**From:** Peter Robson <robsonarchitect@gmail.com>  
**Sent:** 04 December 2023 16:20  
**To:** Tom Nemeth  
**Subject:** Re: [EXTERNAL] Re: Planning Application Incomplete - 23/02610/DOM  
**Attachments:** 1681 100B Location PLAN.pdf

Drawing 1681 100A (Location and Block/Site Plan), the location plan (1:1250) doesn't have a scale bar.

Drawing Number ; 1681 100B

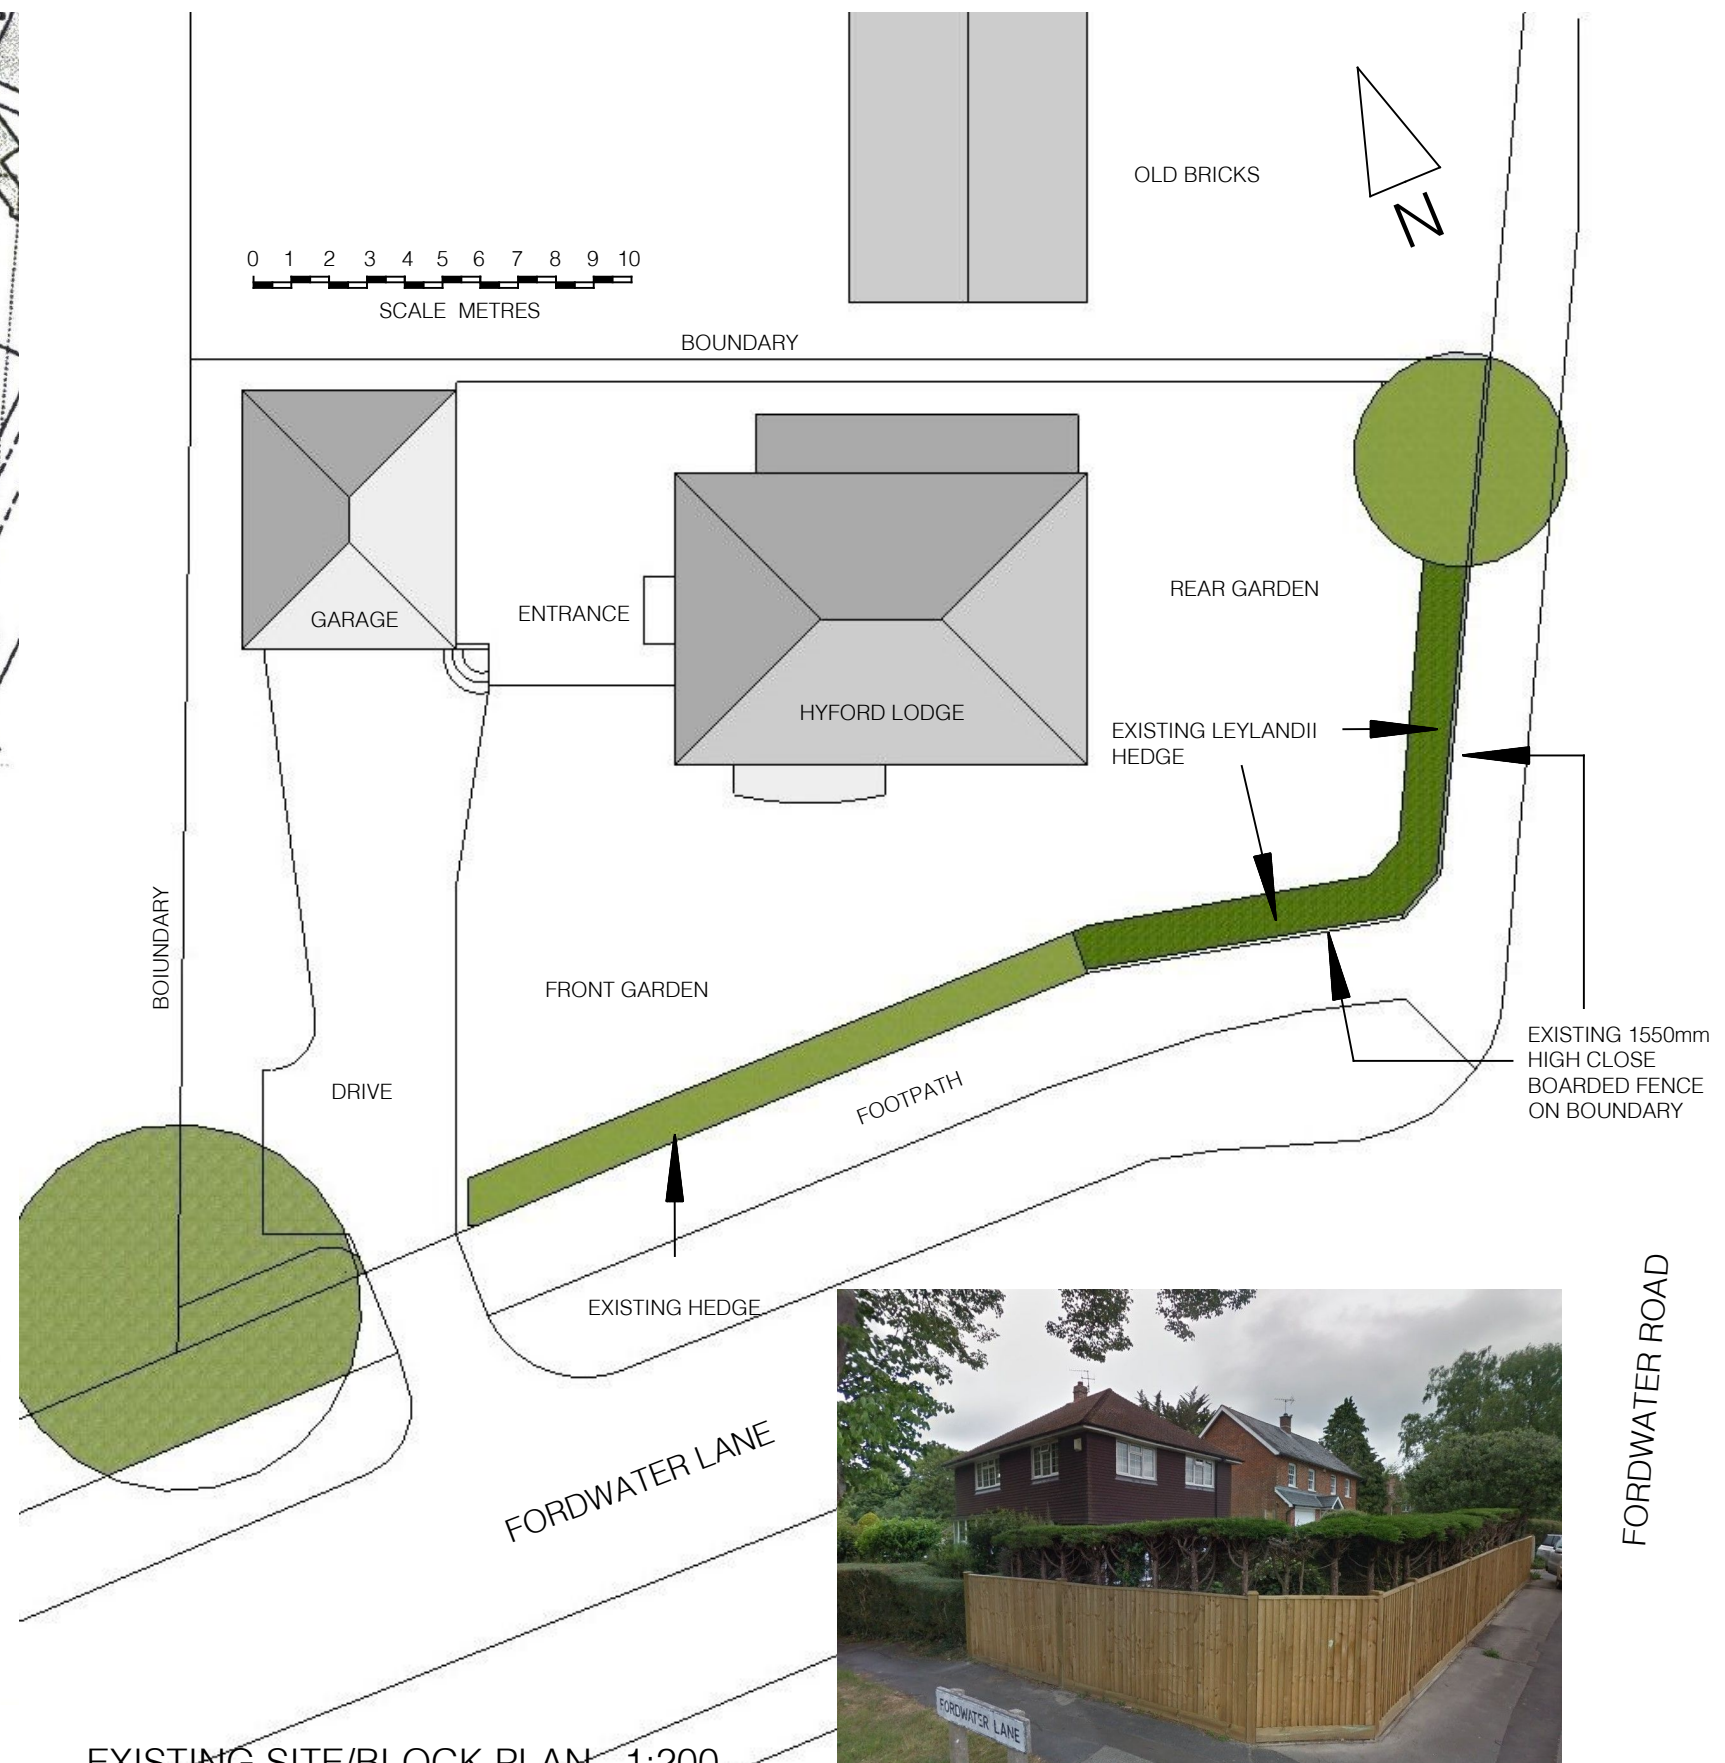
Please review, amend and resubmit.

I attach drawing 1681 100B which now has a scale bar on the location plan.
